29 January 2021

Hills of Gold Windfarm Project – SSD 9679 – Muswellbrook Shire Council Comment

I refer to the Environmental Impact Statement, prepared for Wind Energy Partners, and *Appendix G, Traffic and Transport Assessment* prepared by The Transport Planning Partnership, for the Hills of Gold Windfarm Project SSD - 9679. Council appreciates the opportunity for comment.

HILLS OF GOLD WINDFARM
TRANSPORTATION ROUTE UPGRADE
INTERSECTION OF WYBONG ROAD AND KAYUGA ROAD
GENERAL ARRANGEMENT PLAN

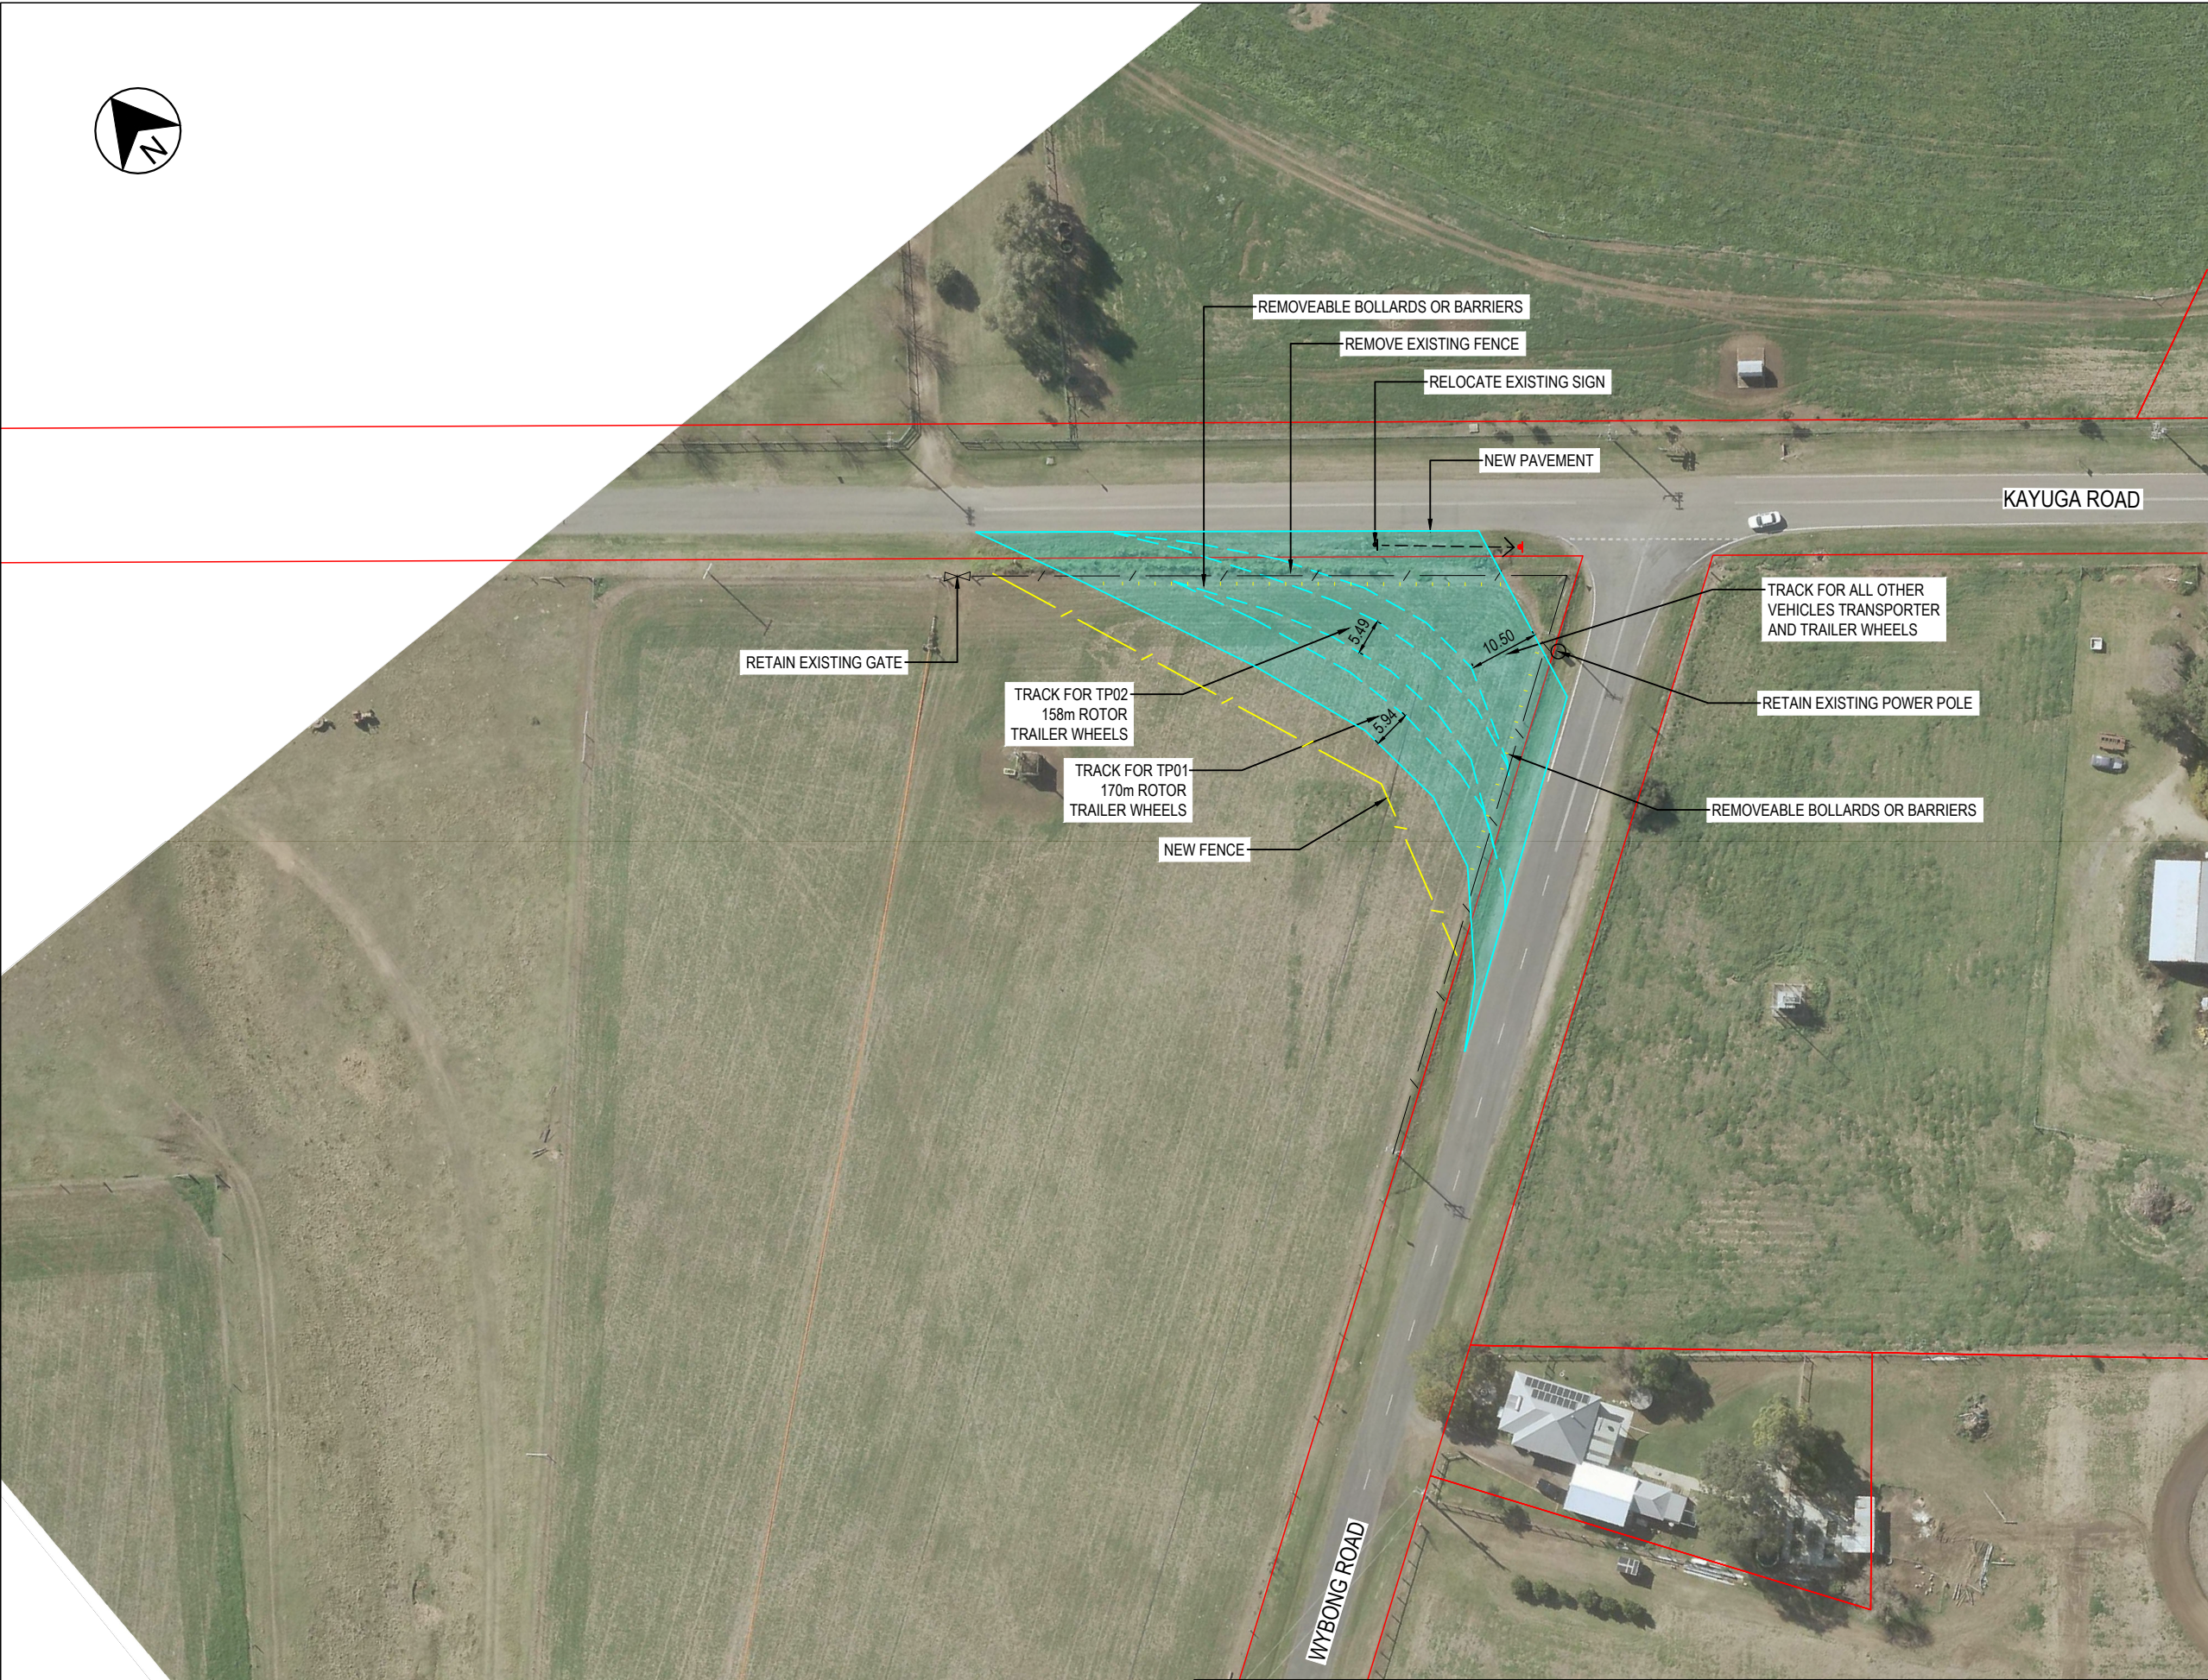
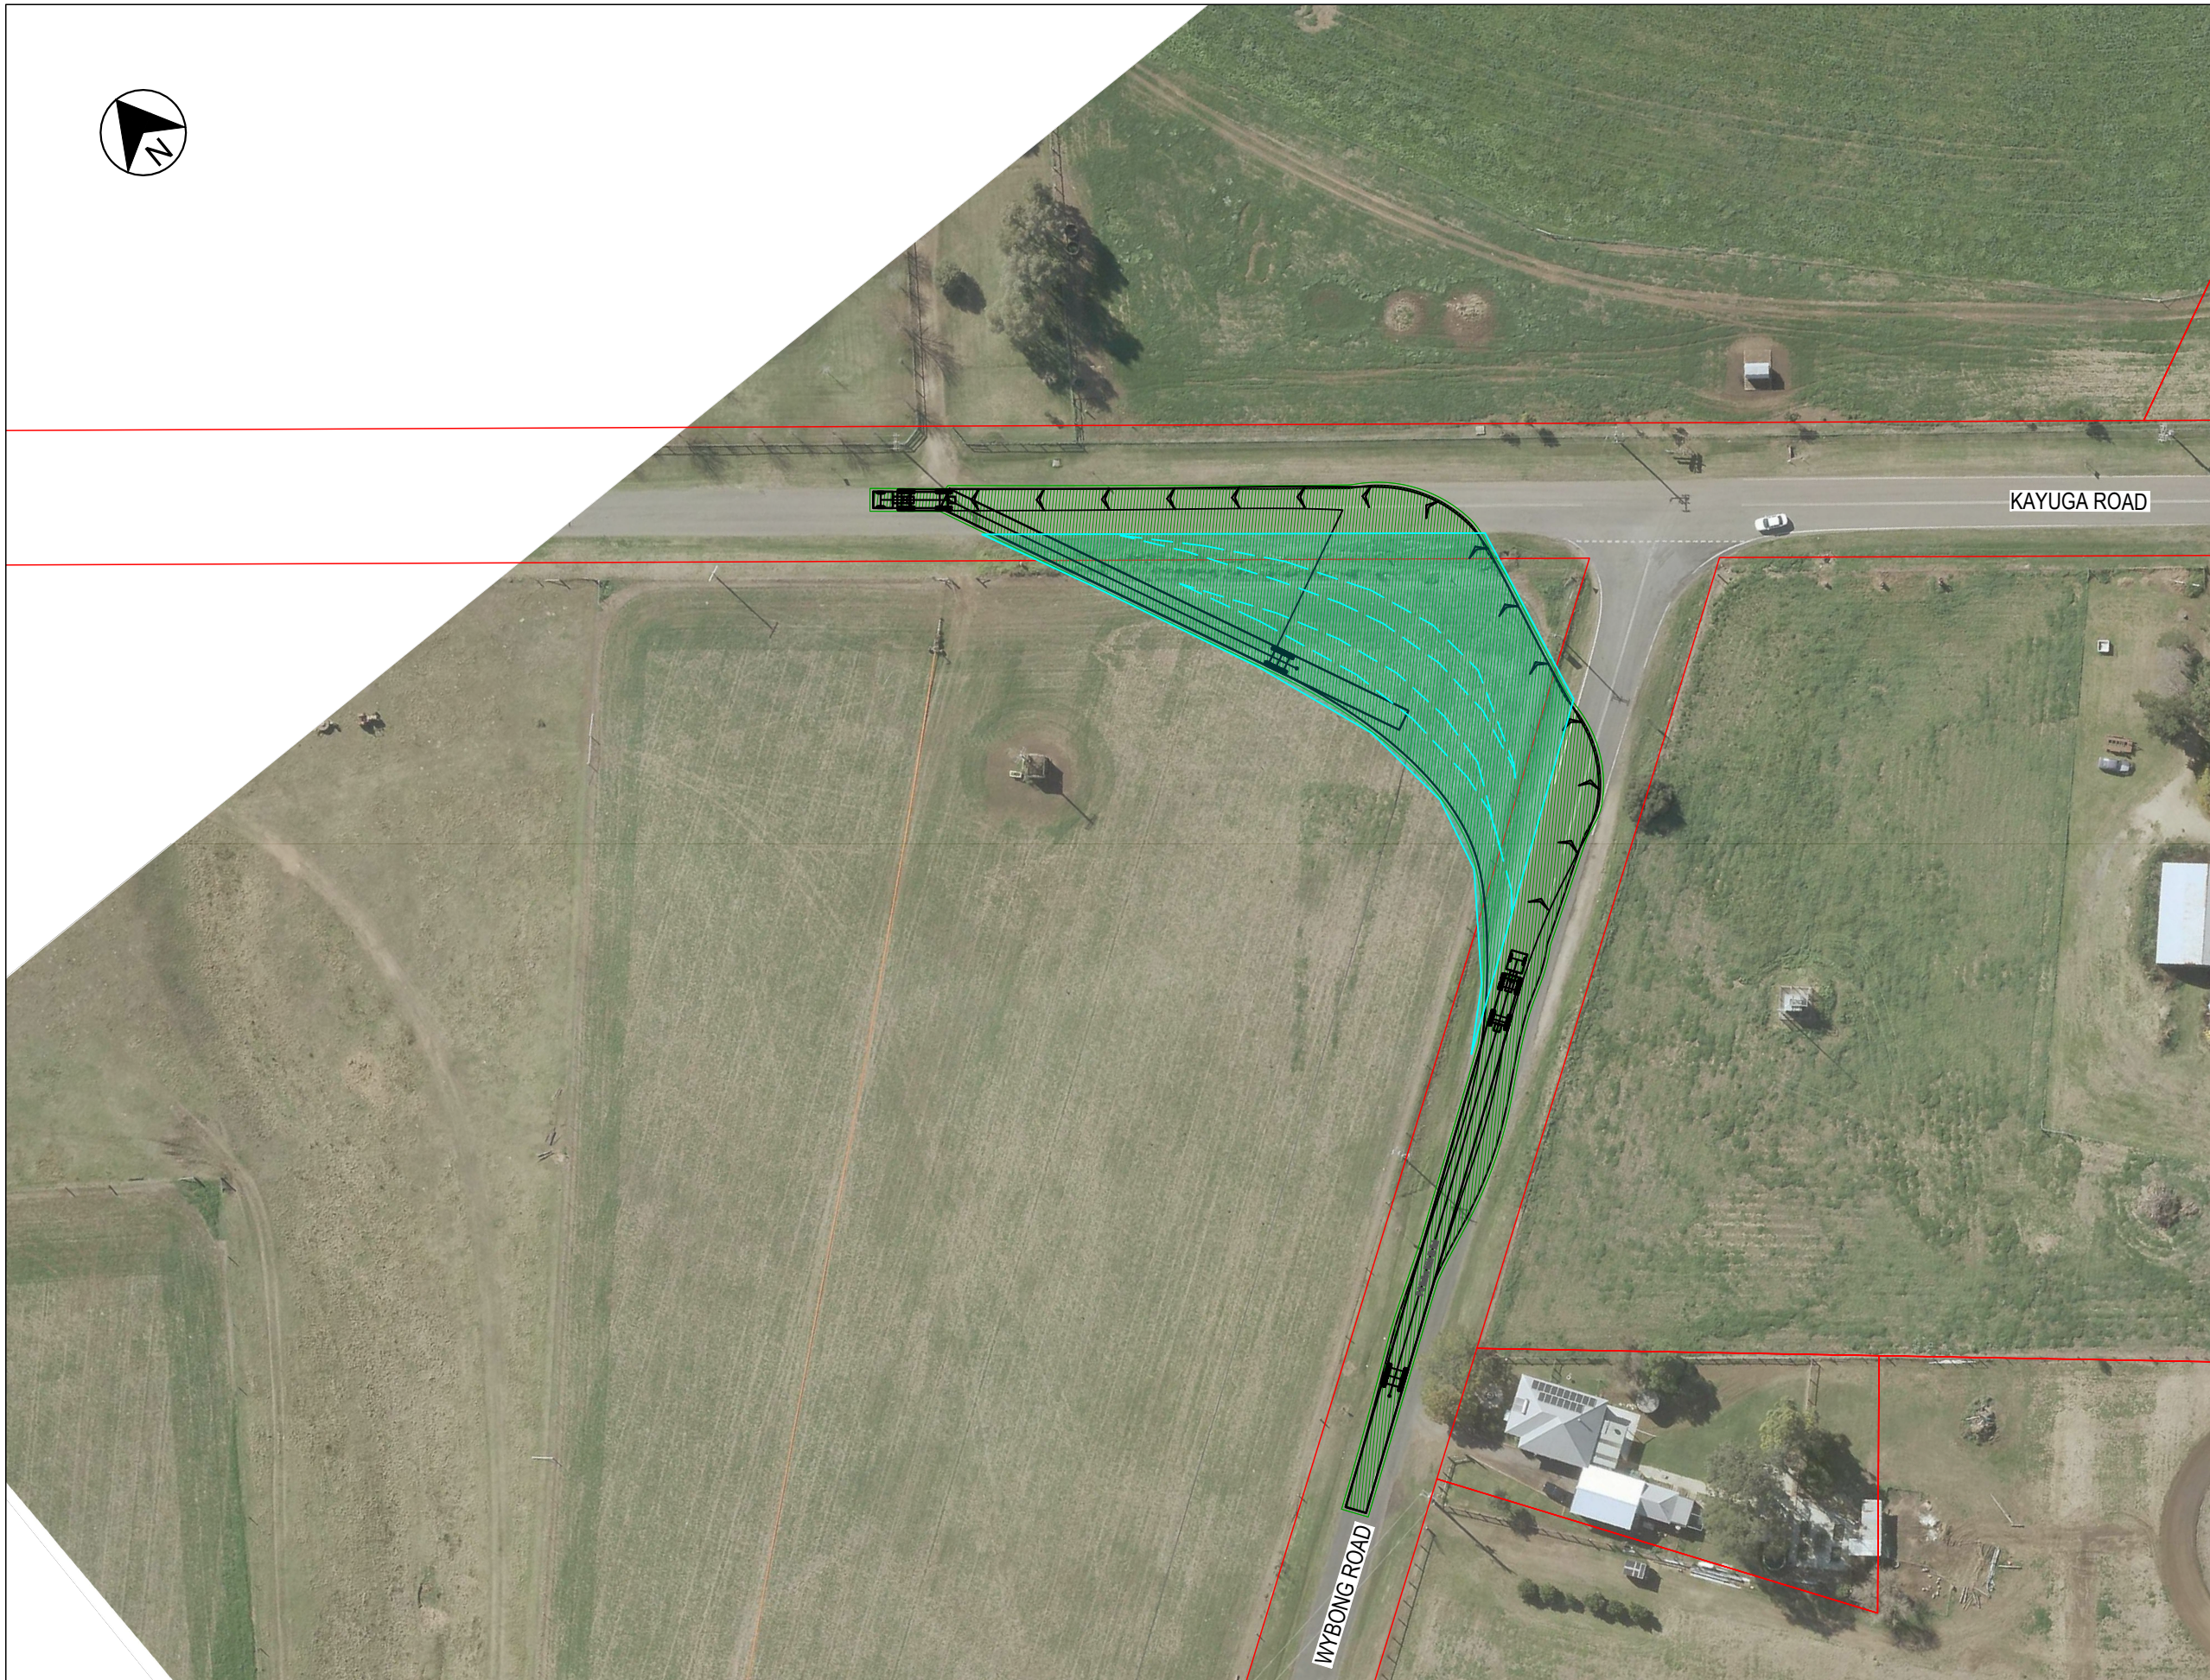
- Golden Highway;
- Thomas Mitchell Drive/Denman Road intersection;
- Thomas Mitchell Drive/New England Highway intersection;
- Bengalla Link Road;
- Bengalla Link Rd/Wybong Rd intersection;
- Wybong Road; and
- Kayuga Road.

6.0 The existing road alignment and constructed standard for sections of Wybong Road, Kayuga Road, Ivermein Street and Dartbrook Access Road are generally of a 'country road' standard with narrower lane widths, unformed shoulders, poor pavement, aged sealed surface, and drainage structures that will not support the proposed repeated heavy loads/turning movements. For example, the Rosebrook Bridge on Wybong Road has been assessed as inadequate structurally for supporting loads greater than local traffic (< 12 tonne mass limit). Several drainage structures and bridges along these roads also require upgrading to increase loading capacity.
